Recommendation Report for Planning Permission

REF NO: BR/31/20/PL

LOCATION: 77 Aldwick Road
Bognor Regis
PO21 2NW

PROPOSAL: Part change of use of ground floor & formation of a first floor rear extension to create 2 No. self-contained studio flats with associated refuse/recycling & cycle store (re-submission following BR/233/19/PL)

Drawing
PROPOSED FLOOR PLANS

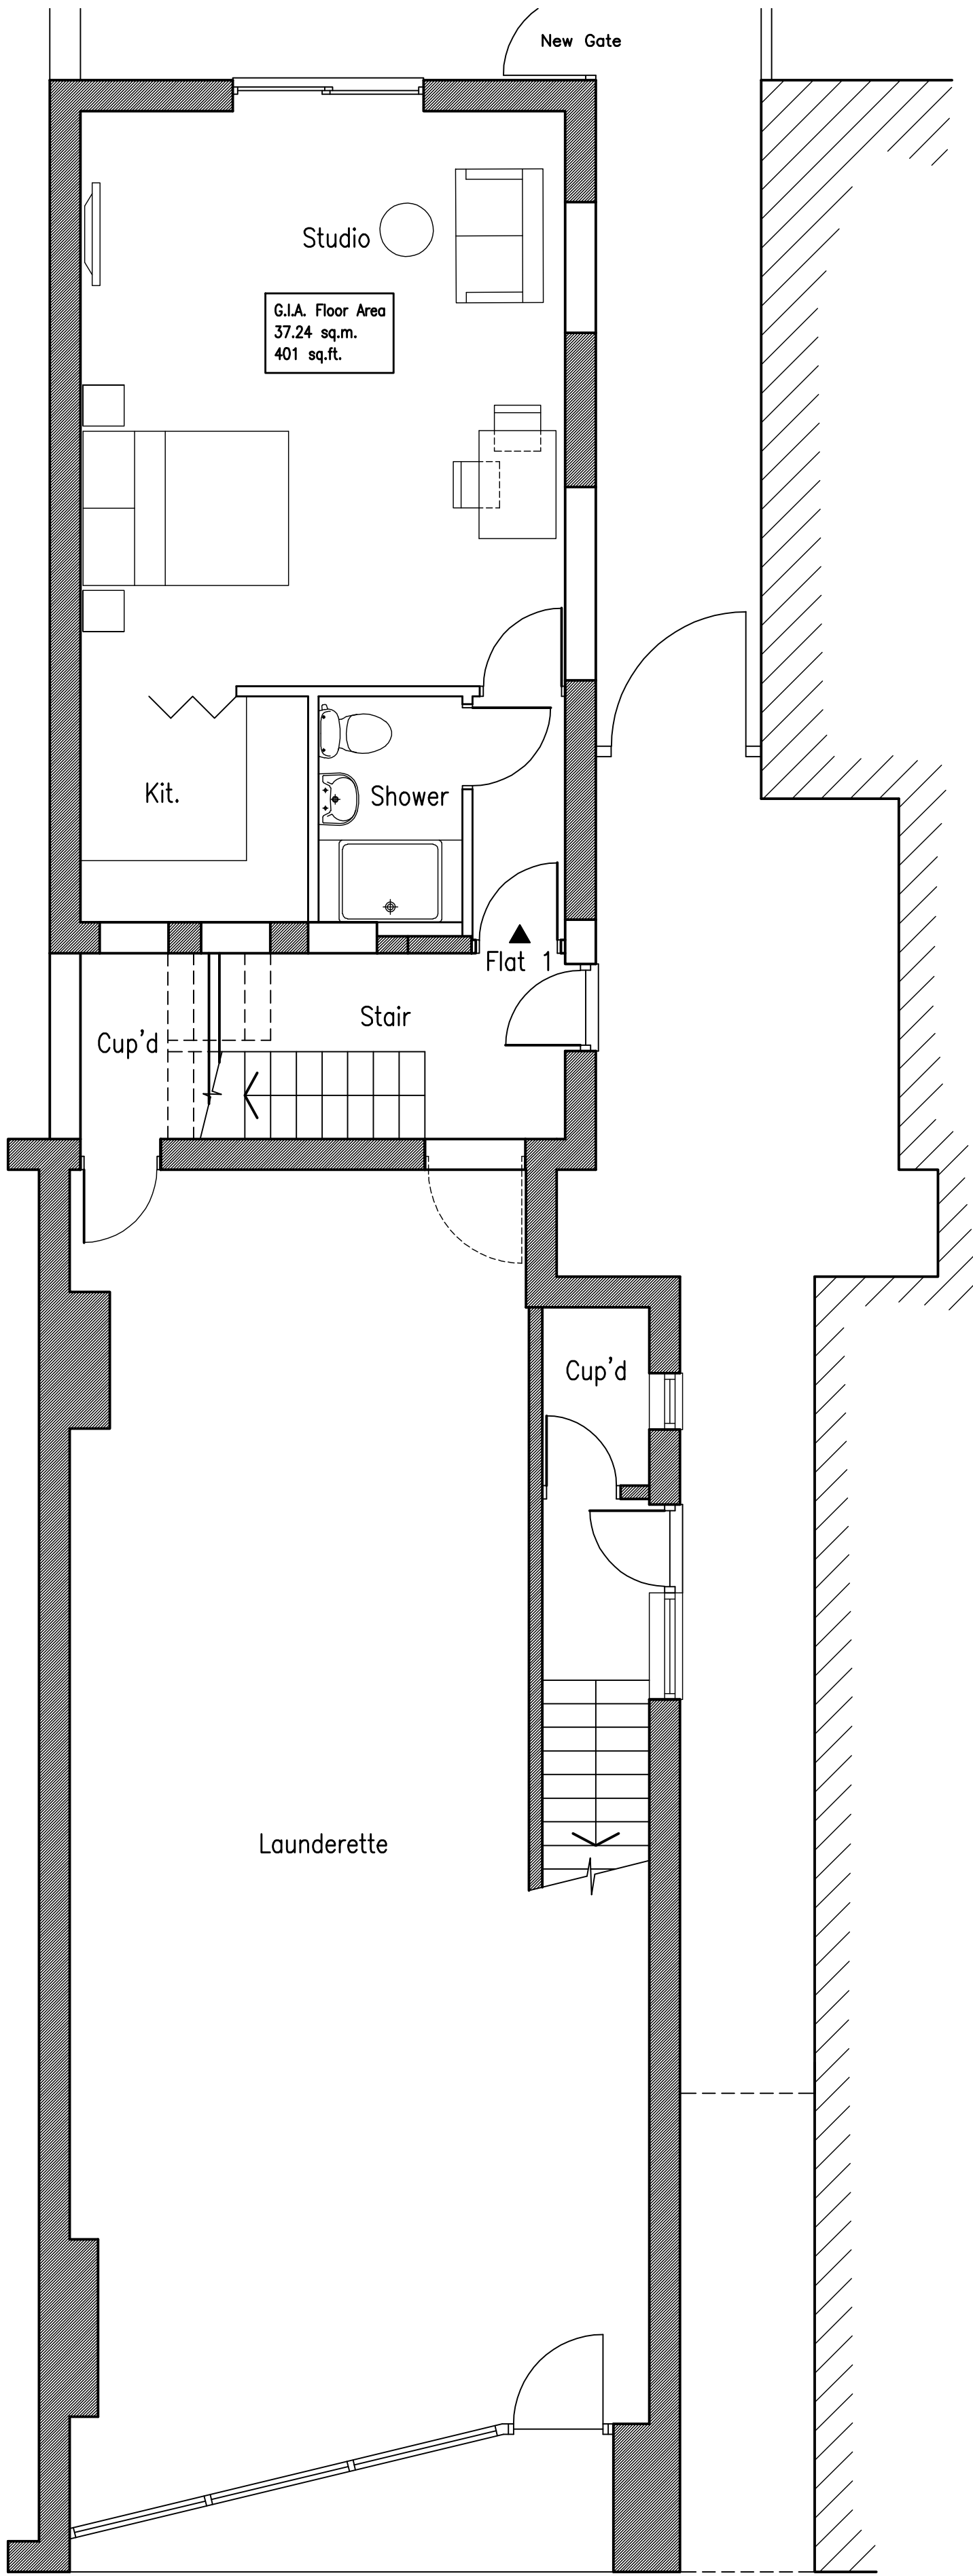
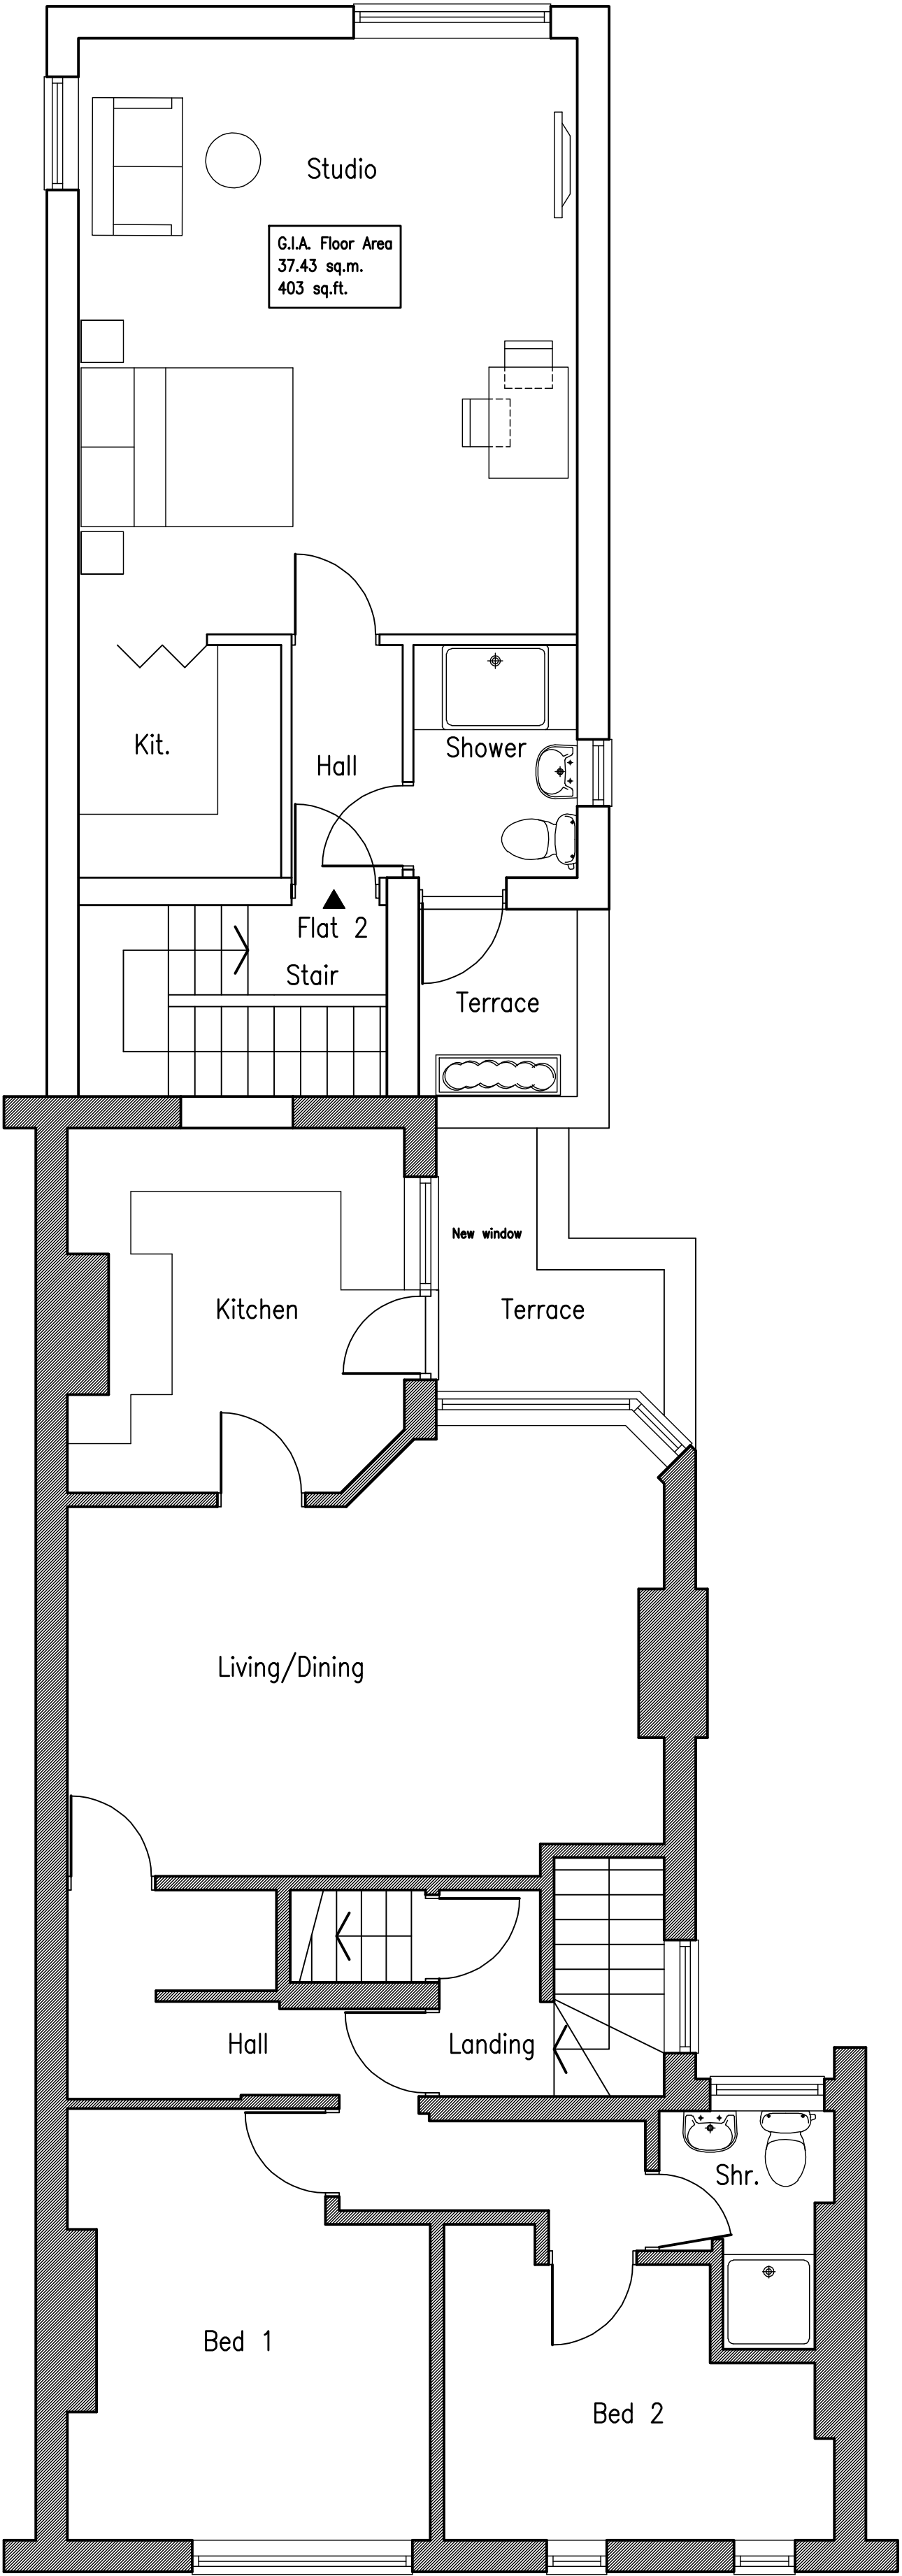
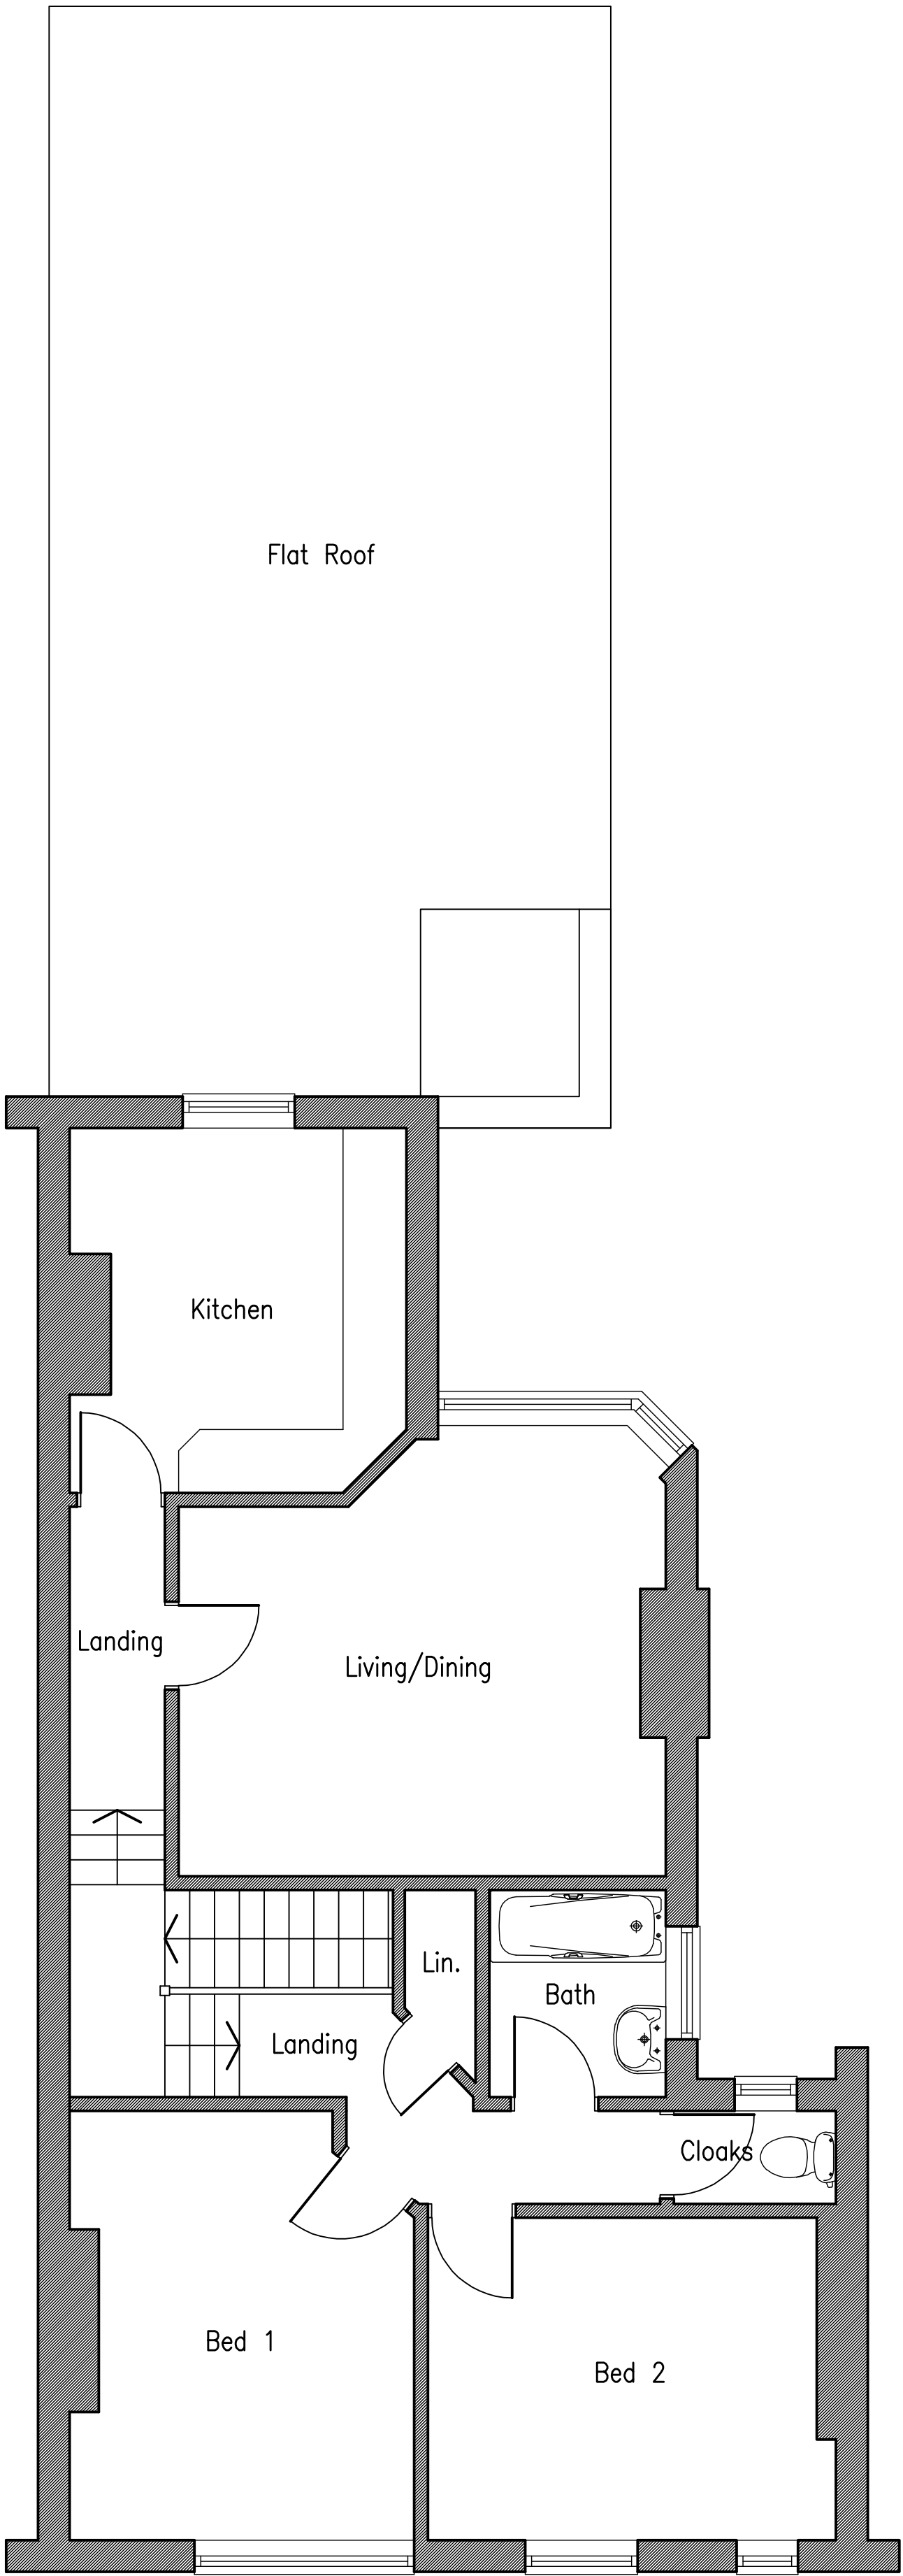
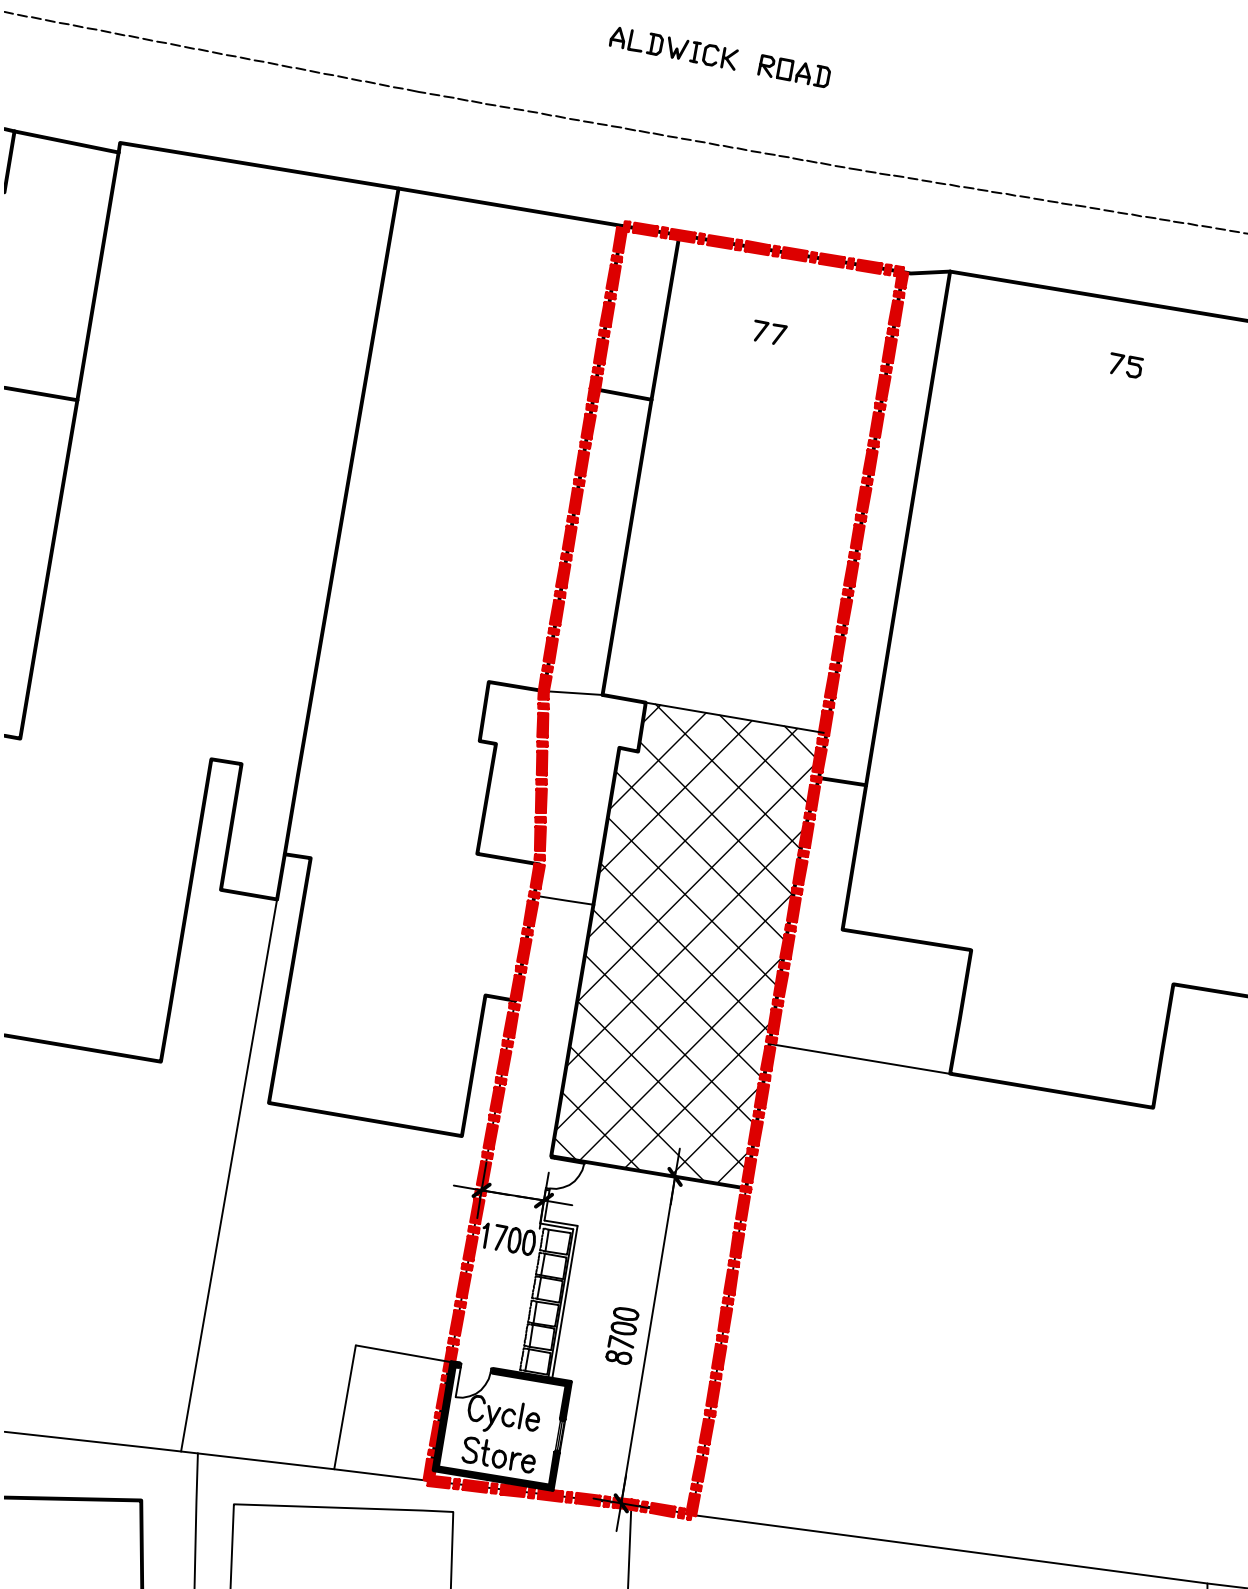
There should be adequate fire separation between the commercial unit and the communal staircase serving the new self-contained flats

- The rear under stairs cupboard accessed via the laundrette should afford 30 minutes fire resistance. If there is a source of ignition present within this cupboard then interlinked detection should be fitted within the cupboard too

The first floor rear extension would comprise approximately 2.7m of additional height and would feature a flank wall with bathroom door abutting the terrace area of the first floor apartment at 77 Aldwick Road. The proposal introduces another small terrace adjacent to the existing balcony of first floor flat at significantly lower level which would set the flank wall of the proposed extension approximately 1.7m further, however still within a distance of 4.5m. This terrace was probably intended for a mitigation of the

The development would abut the terrace of No. 77 with a flank wall of 1.8m high (from the floor level) of the first floor flat within a distance of 4.5m and would enclose the southern aspect of this already limited outdoor amenity space of No. 77. Such a level of enclosure would be unacceptable and would be harmful to the limited private amenity space afforded to residential properties in such a location. The first floor extension would also be located approximately 2m from the first floor terrace of No. 79 Aldwick Road. The development would be at the same height as the terrace and would also feature windows along the elevation obliquely facing the first floor terrace of No. 79. This proximity to the terrace of No. 79 would result in an undue sense of enclosure that demonstrably harms the level of amenity afforded to the first floor apartments at Nos. 77 and 79 Aldwick Road. Due to the proposed extension the existing kitchen window of the first floor flat would be removed (or facing to the proposed stair case) and a new window is proposed on the western elevation facing directly the flank wall of No79 with habitable windows within a distance of less than 3m.

The development results in a visual sense of enclosure owing to the close 3m relationship to nos. 75, 77 and 79, combined with the height of approximately 1.8m from first floor level. This would materially affect the primary living accommodations of the adjacent first floor apartments (nos. 75, 77 and 79) and would result in a tunnel effect especially on the existing occupants of Nos 77 and 79. Such a design results in harm to the amenities of neighbouring occupiers.

The first floor studio apartment would introduce a large habitable window within 8.7m of the southern boundary of the site. The close proximity of the proposed first floor apartment would result in overlooking into the rear private amenity space of nos. 10 and 14/16 Stocker Road. This matter was raised within the refusal of planning permission BR/63/18/PL and recent application BR/233/19/PL.

- 1 The first floor extension to the rear of 77 Aldwick Road as proposed will result in an overbearing impact on, and loss of outlook to, the amenity of the existing windows of the first floor residential flats in the rear of 75 - 79 Aldwick Road. In the absence of a full BRE sunlight/daylight study there Local Planning Authority has not been satisfied that there will not be a demonstrable harmful loss of sunlight/daylight to neighbouring residential properties. The proposal is therefore contrary to policies D SP1, D DM1 and QE SP1 of the Arun Local Plan and the National Planning Policy Framework.

- 2 The new first floor studio apartment's window on the southern elevation of the proposed extension will look out towards the rear private amenity spaces of Nos.10 and 14/16 Stocker Road at a distance of around 8.8m. This will result in a loss of privacy to the adjacent amenity spaces of nos.10 and 14/16 Stocker Close and the proposal is therefore contrary to policies D DM1, D DM4 and QE SP1 of the Arun Local Plan and National Planning Policy Framework.
